File: 16196

April 4, 2017

RE: 1210 BRIGHTON AVENUE  
REVISIONS TO HOTEL REDEVELOPMENT

C2.1

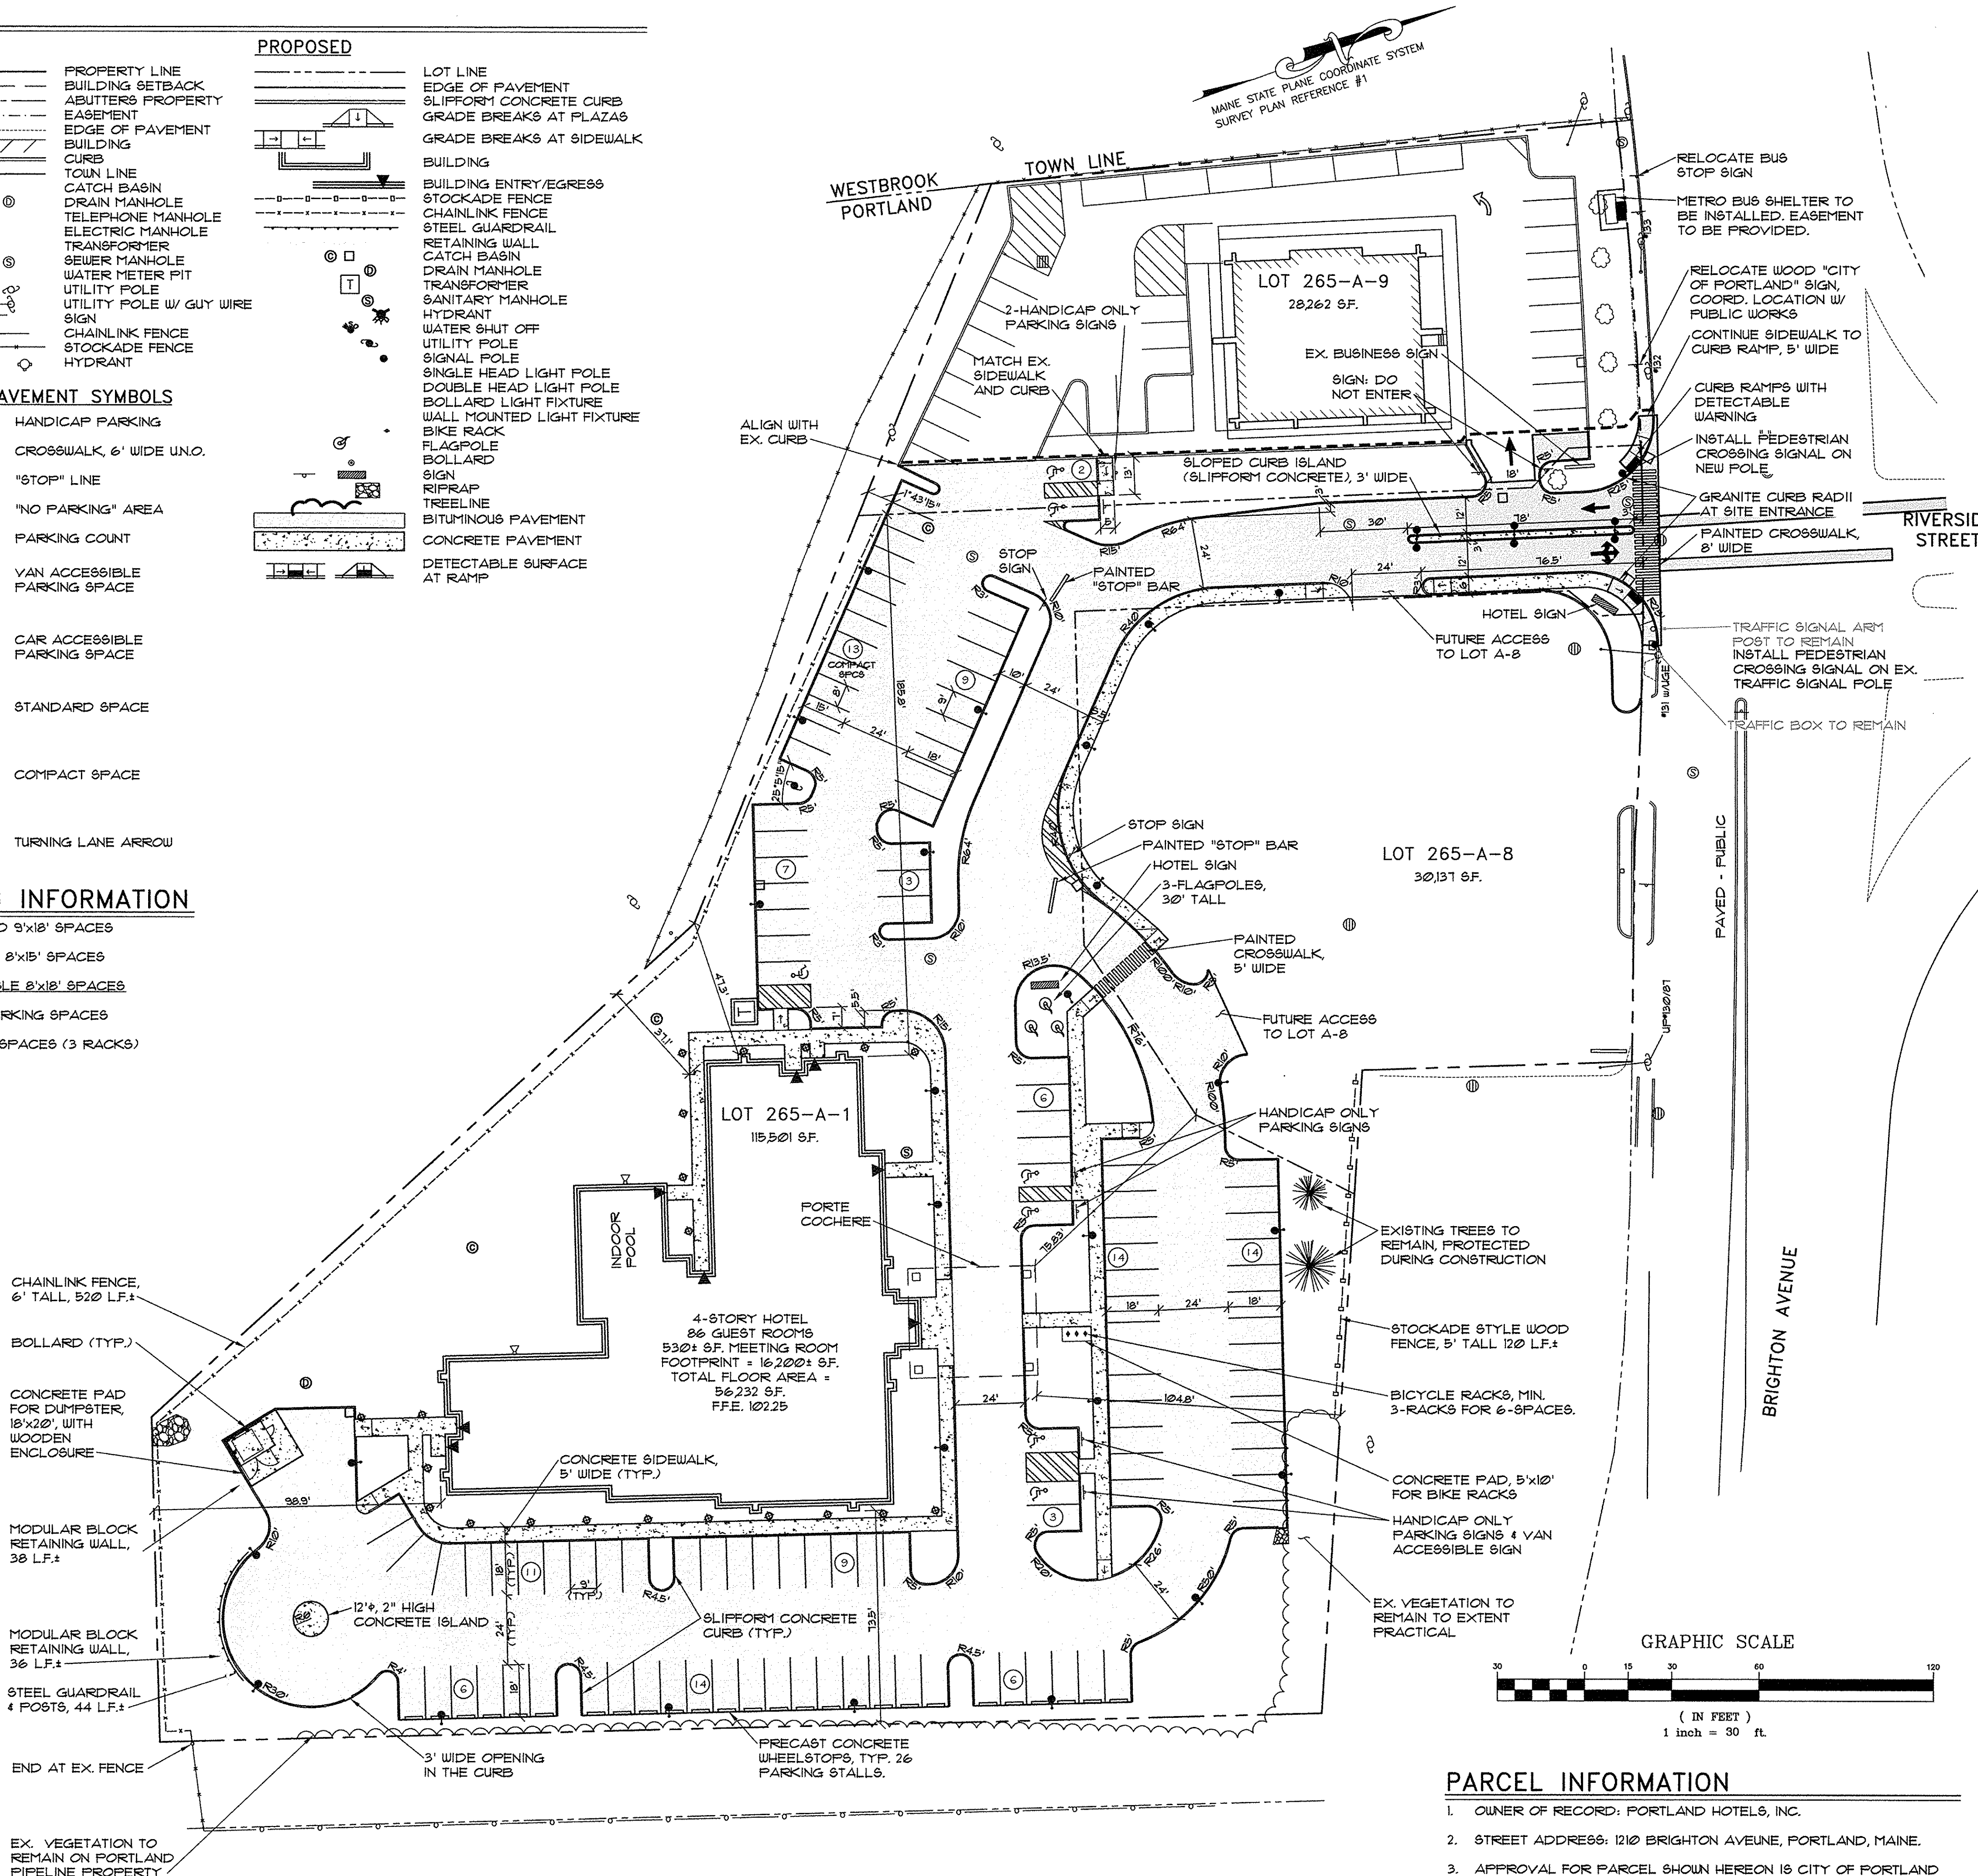
- 1) The Hotel building's first floor is now one level. Grading at the West entrance was revised.
- 2) The two dead end parking lots were reconfigured to allow flow through traffic.

- 3) The ADA parking spaces for the Denny's Restaurant were revised to remove them from the main access drive.
- 4) In accordance with Lease Holder for the Hotel, the end of the paving on the east side was reconfigured to allow passenger vehicles to turn around without a backing maneuver.

- 5) The main access drive was reconfigured to provide a more direct access to the entrance of the Hotel and additional space for the possible redevelopment of the front lot.

- 6) The lot lines for the 3 lots have been modified to better suit each use.
- 7) The water lines to the Hotel have been revised to be located on the lot. The line uses the main access drive for servicing the Hotel.

- 8) We have revised the grading in the east side, using wheel stops to allow storm water to flow onto the City right of way in the same configuration as exists today. This eliminates the need for the easement and the three rip rap aprons.

9) We have revised the landscaping and lighting to match the new layout.
